Ribble Valley Borough Council
Housing & Development Control

Your ref: 3/2022/1180
Our ref: D3.2022.1180
Date: 13th February 2023

Application no: **3/2022/1180**

Address: **Pinfold Farm Preston Road Ribchester PR3 3YD**

**Drawing Status:** Site Plans

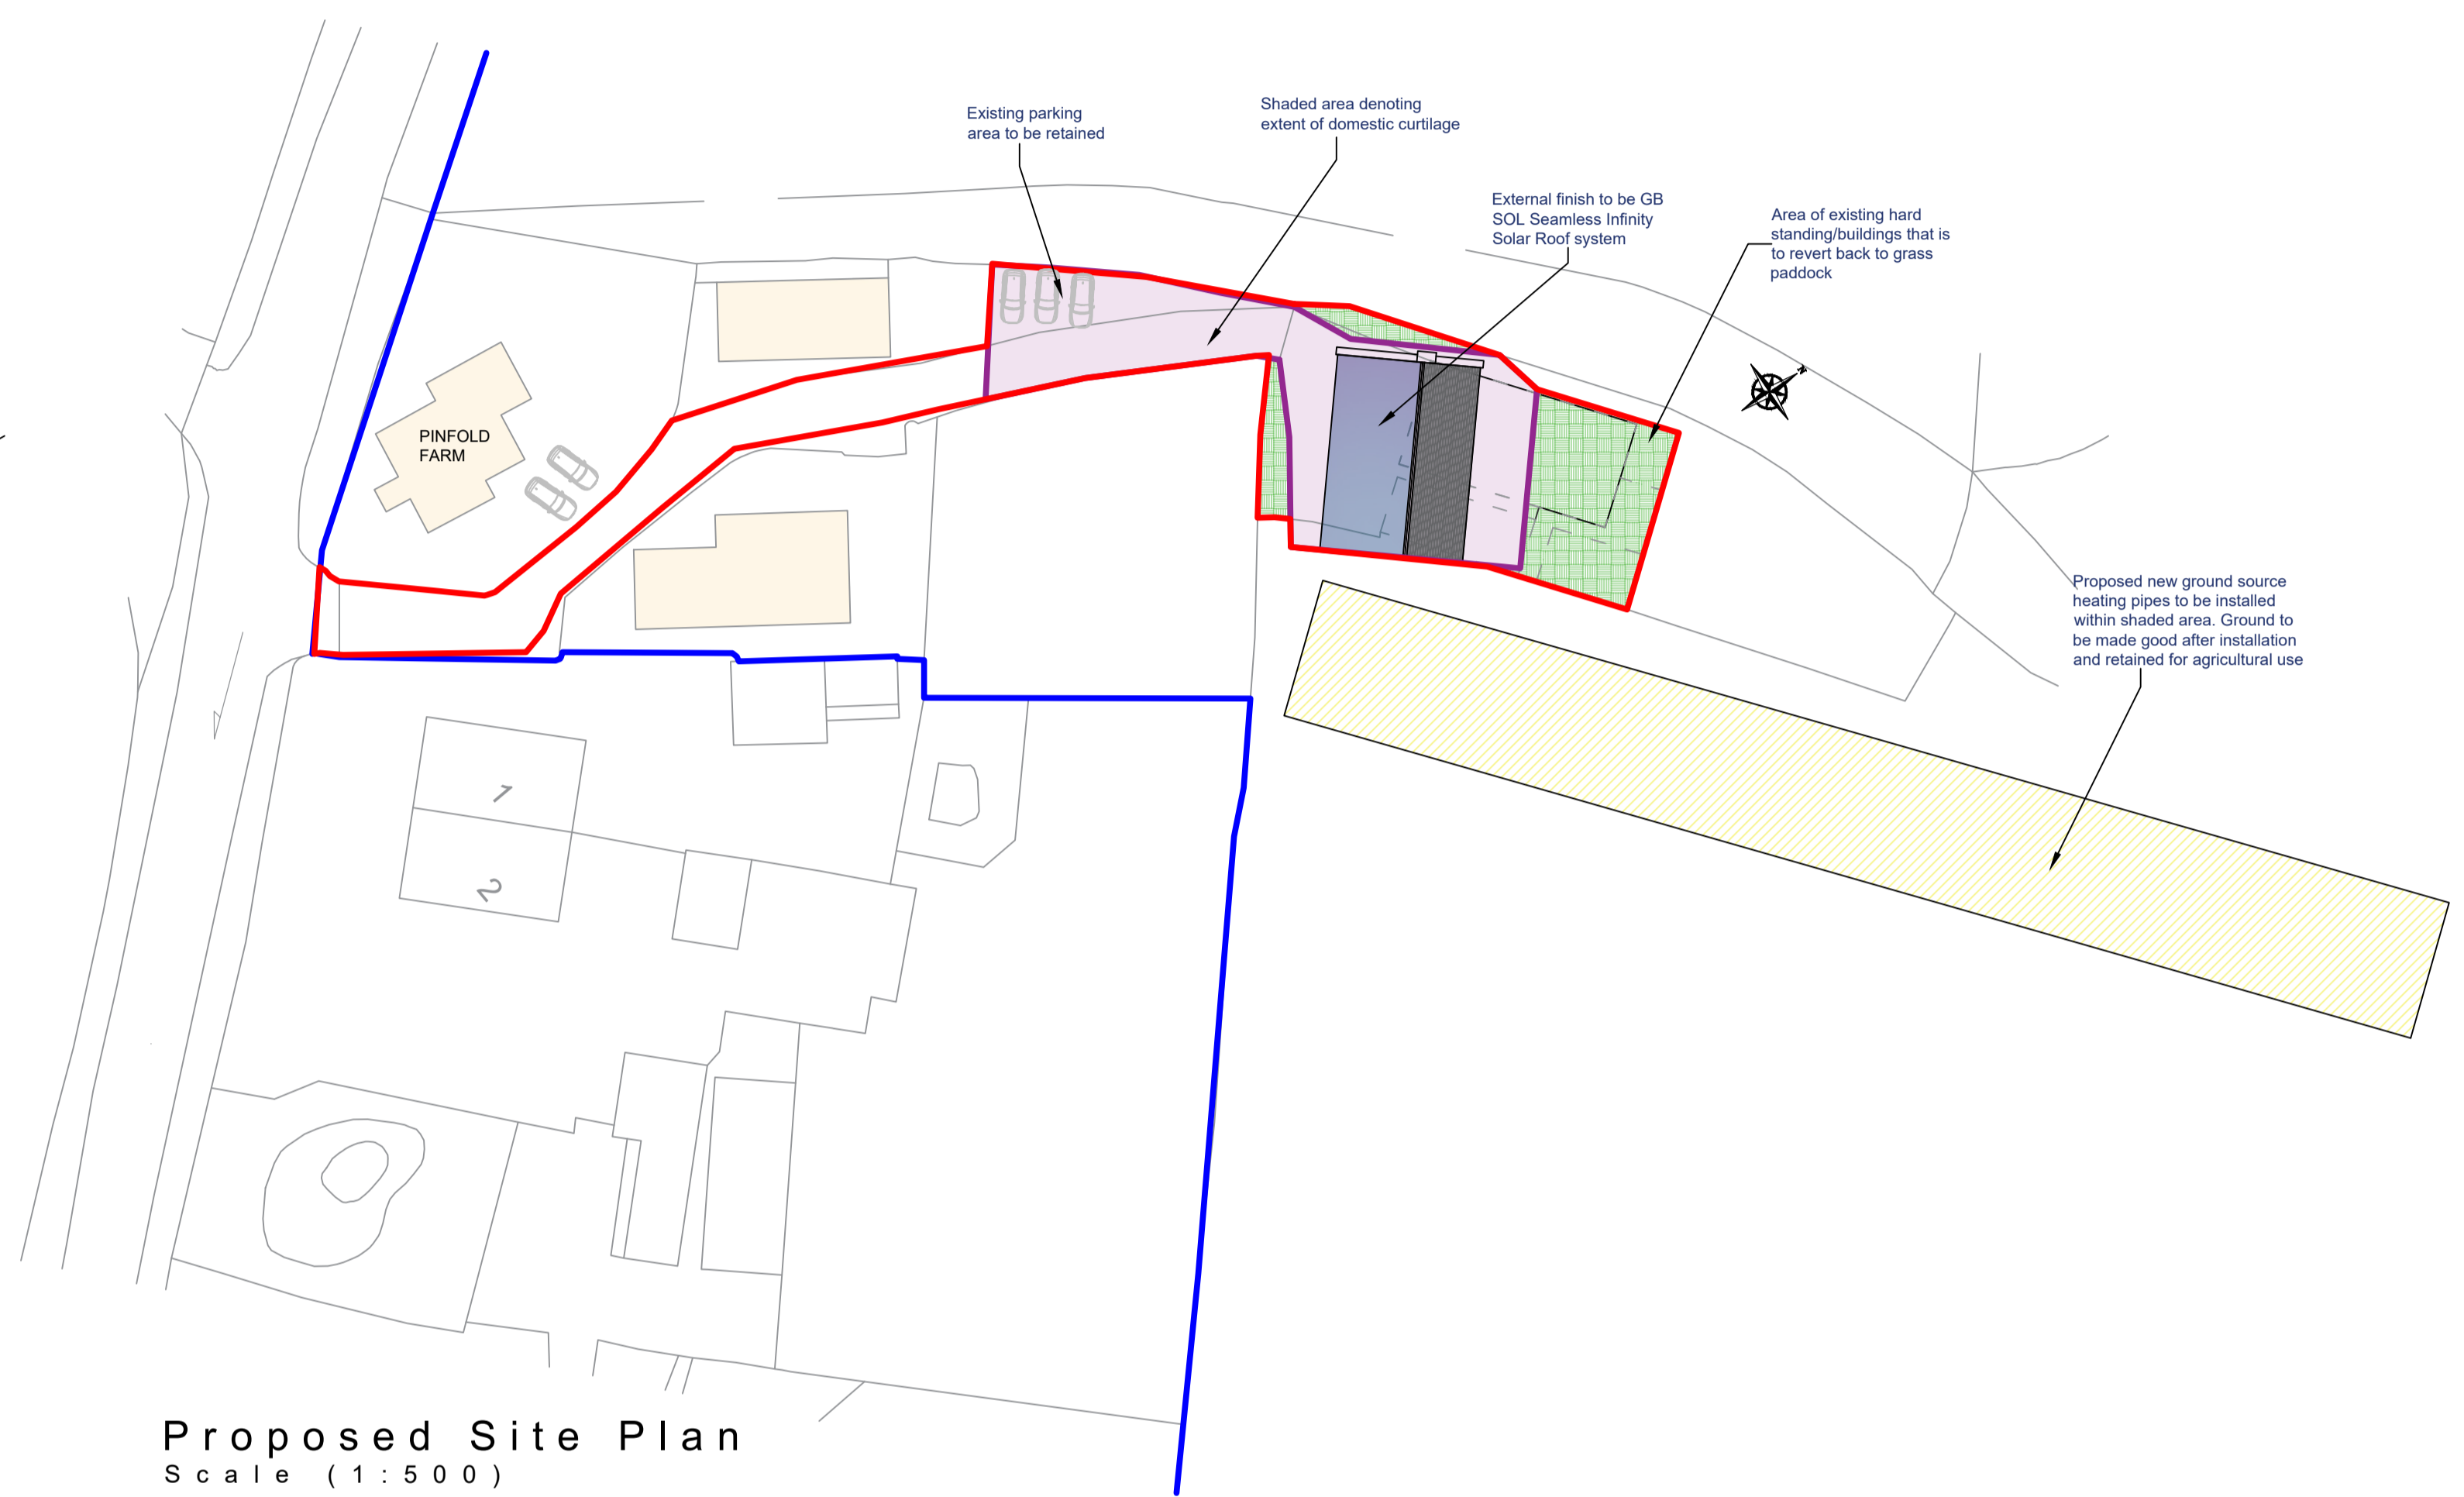
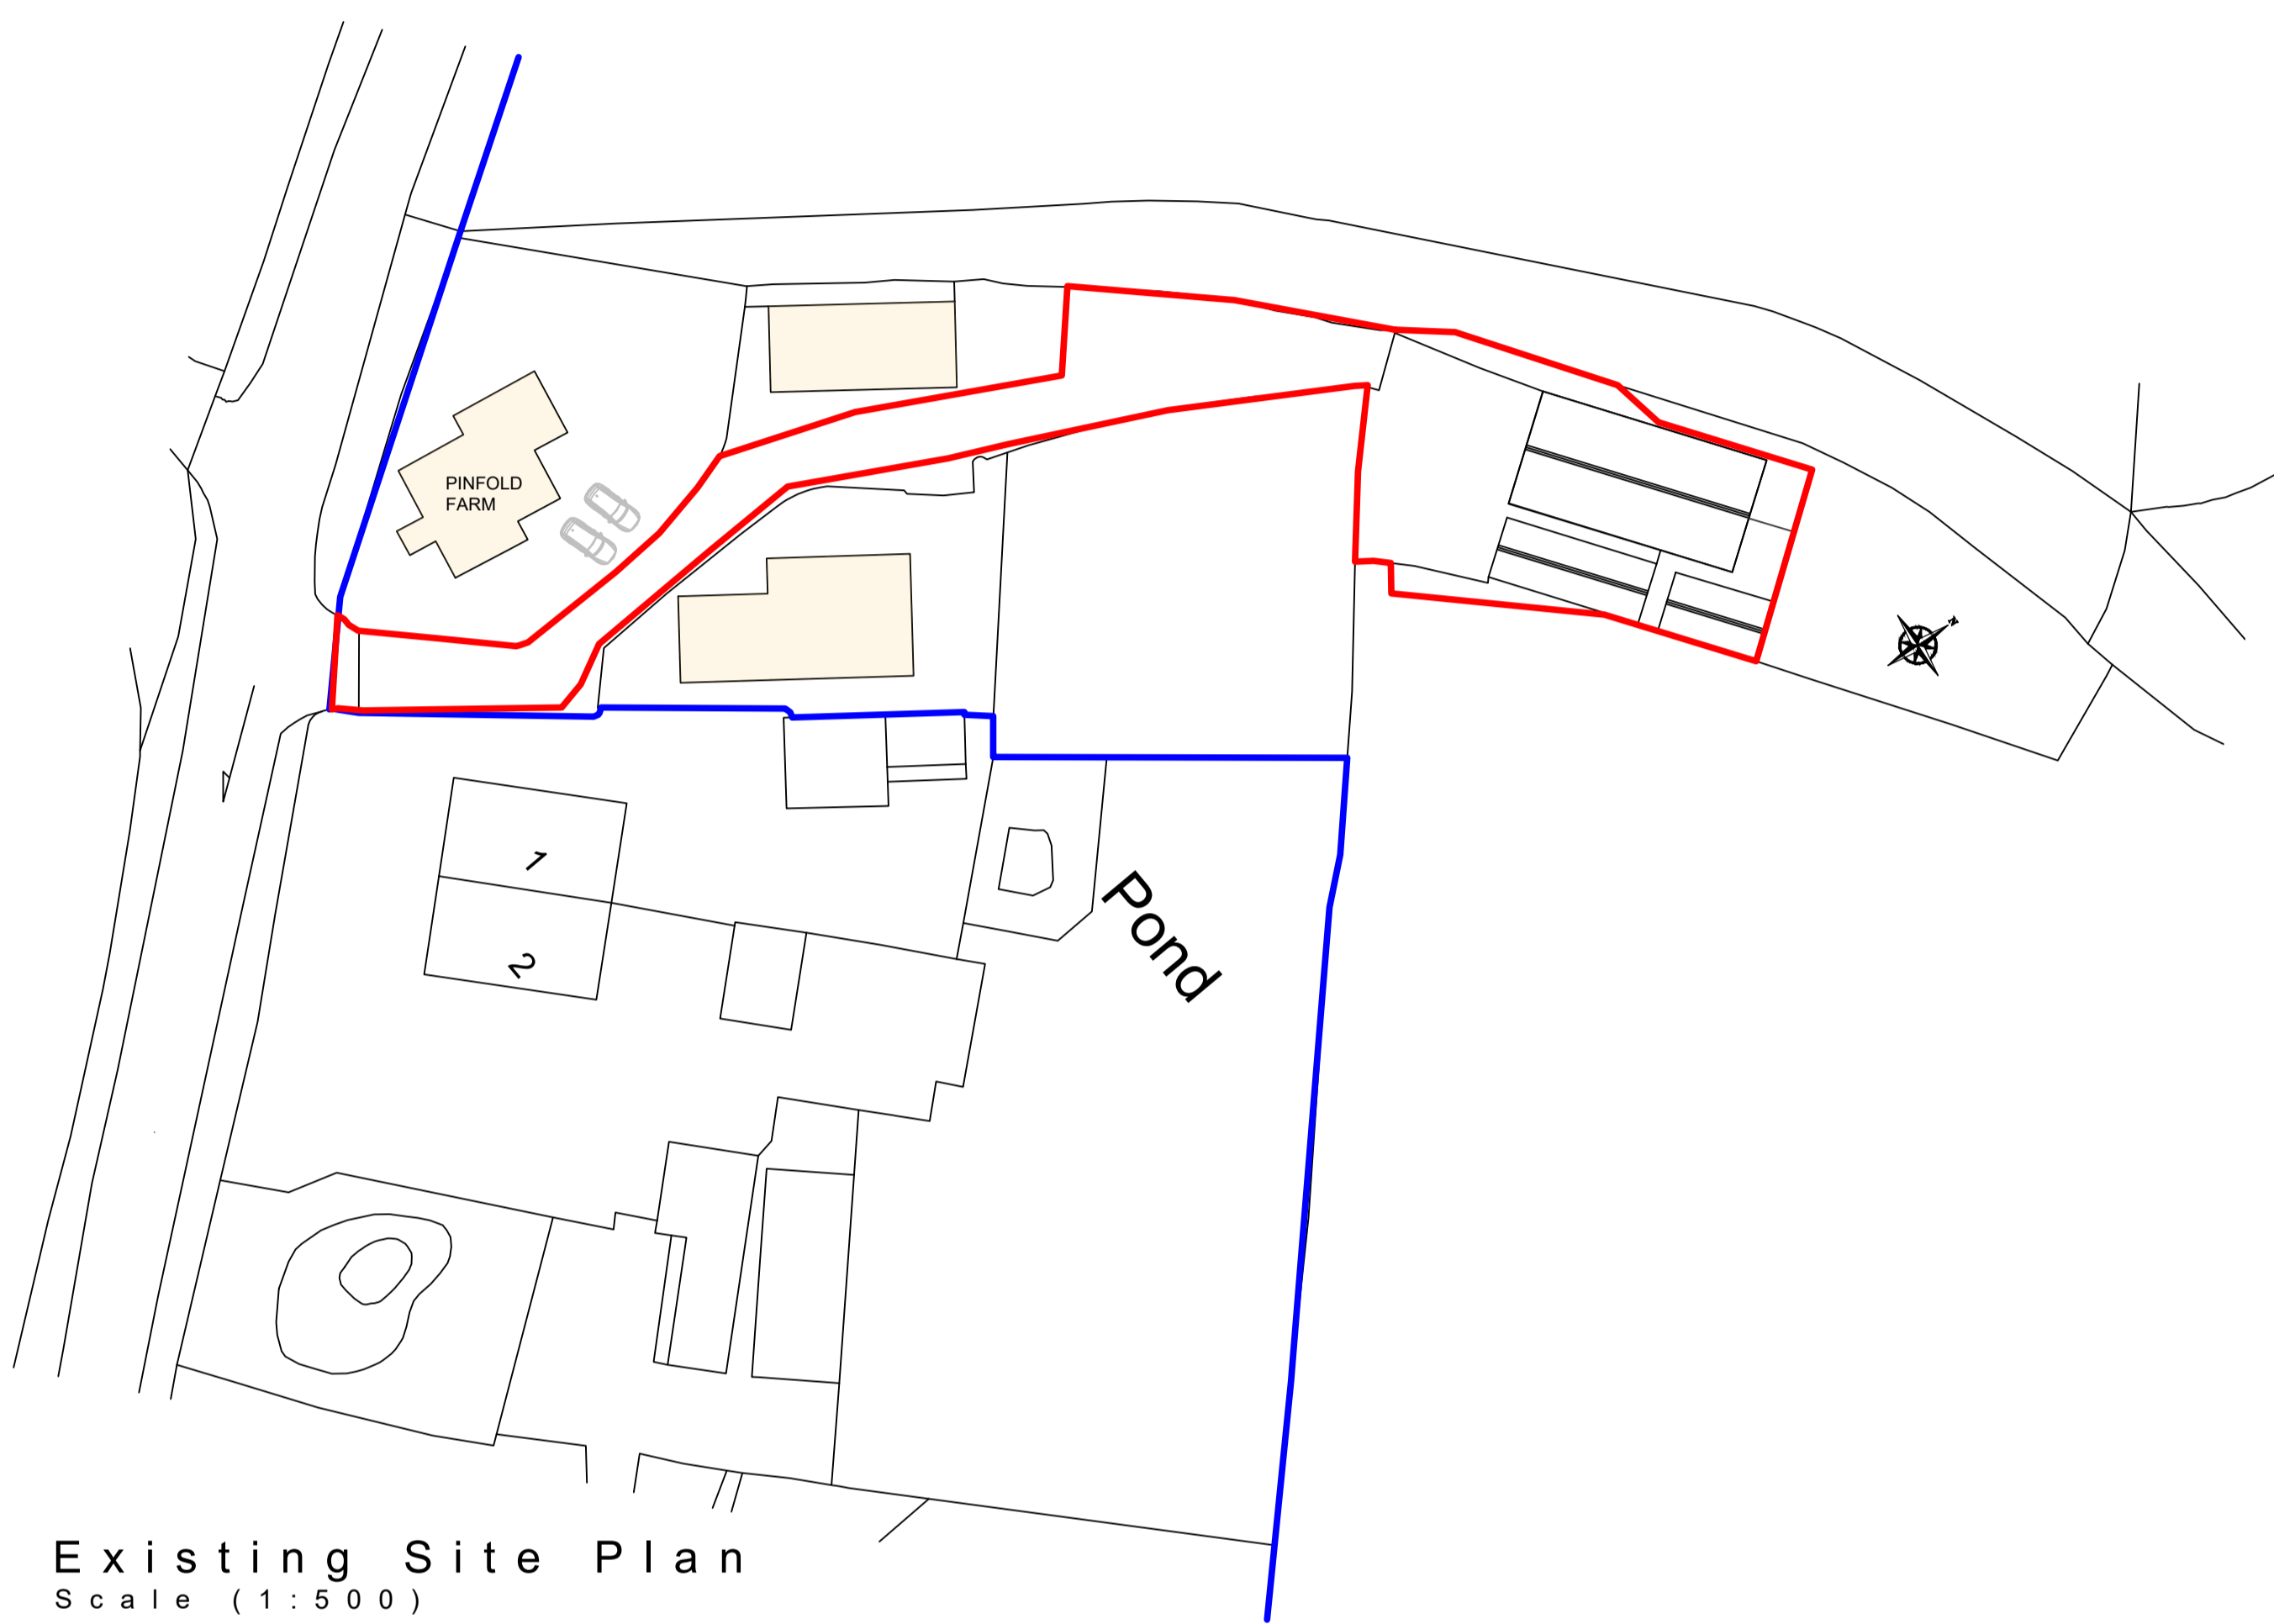
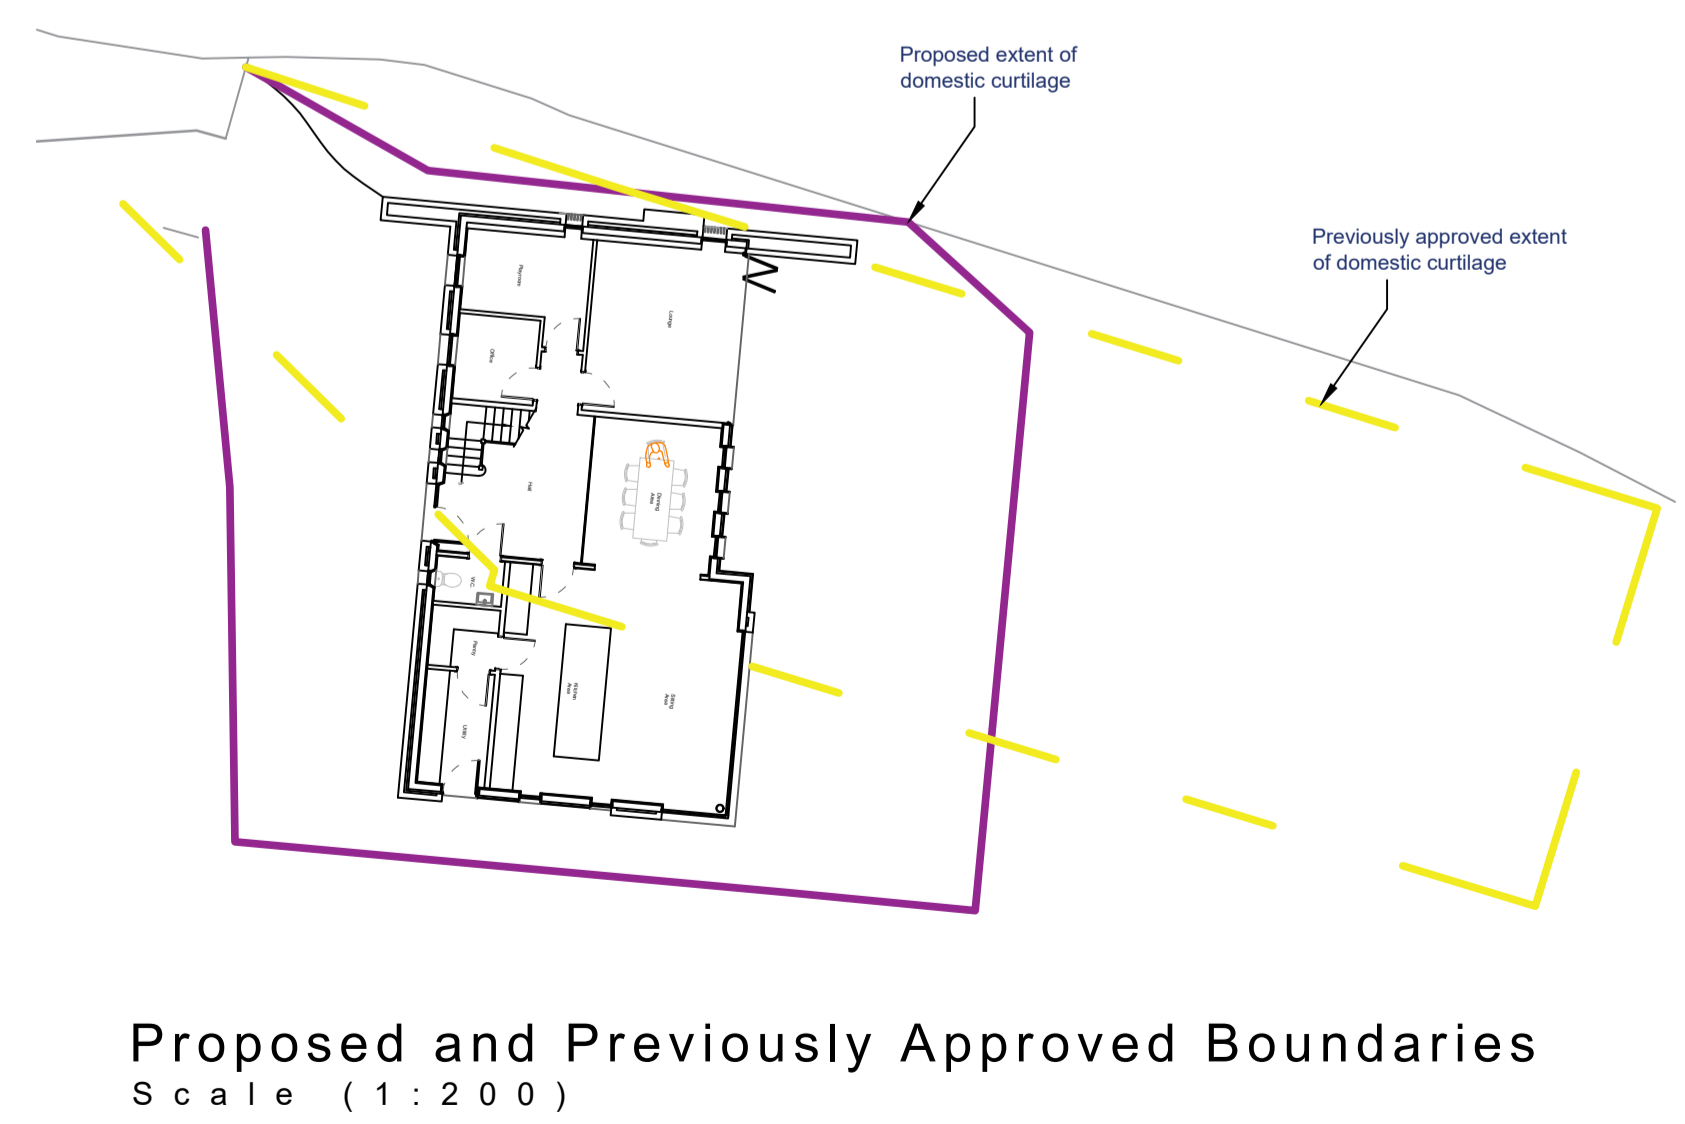
The LHA have reviewed Holden drawing reference 009 titled "Site Plans" and are aware that the access to the proposal has already been approved by the LHA under application reference 3/2021/1271 and 3/2020/0855, which was for the same scheme at the site. Therefore, given the access remains unaltered and the proposal will not fully intensify the use of the access, the LHA have no objection to the proposal.

The LHA have reviewed Holden drawing reference 009 titled "Site Plans" and are satisfied that the parking arrangements comply with the LHAs parking guidance found in the Joint Lancashire Structure Plan. Therefore, the LHA have no further comments to make.

1. The development hereby permitted shall not be occupied until such time as the parking and turning facilities have been implemented in accordance with Holden drawing reference 009. Thereafter the onsite parking provision shall be so maintained in perpetuity.
